Planning Application Ref: A/166/21/T

Location: Land adj. to 12 Quiet Waters Close, Angmering, BN16 4DG

Description of works: Remove large branch of 1no. London plane tree (T54) approx. 3m above ground level leaning towards neighbouring property

PROJECT	Quail Waters, Roundstone Lane, Acropora
TITLE	Detained Land-zipco Proposals

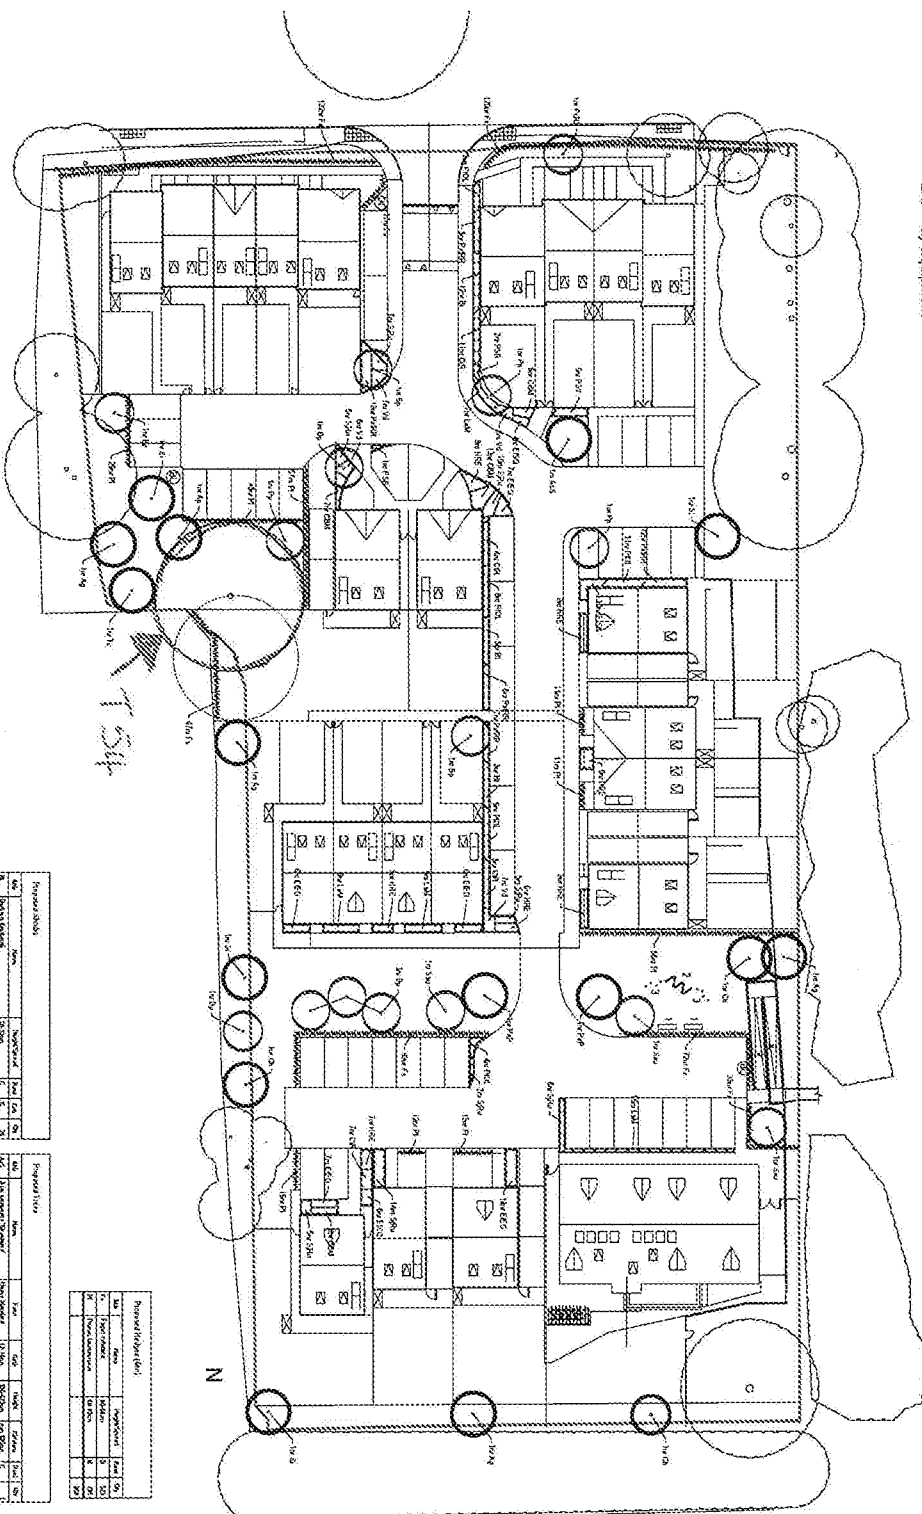
T54 London plane / *Platanus x hispanica* Height: 10-15m, Radial spread: 5-10m, Age class: Early mature

- This tree appears to be in a fine physiological state with an attractive crown profile. It has been purposefully retained during recent development of the site and is in harmony with its wider surroundings. A focal point within the Close, it is a tree of high growth potential and amenity value.
- The removal of the limb will ensure long-term clearance of garden boundary fences and remove a potential interference with vital utility apparatus. This can be achieved without detriment to the tree's long-term health and aesthetic value.

- The work proposed is justified on arboricultural grounds.
- If undertaken to a high standard and at the right time; then it is unlikely to have an adverse effect on the tree's long-term vitality and visual amenity.

- I recommend **CONSENT** for this application, subject to the following condition:

Part a) Where whole branches are to be removed and final cuts made close to the trunk or branch union they are to be made as shown in Figure 2 of BS3998:2010

Part b) Where branches are to be shortened back the final cuts are to be made at the correct angle shown in BS3998:2010 and adjacent to a live bud or lateral.
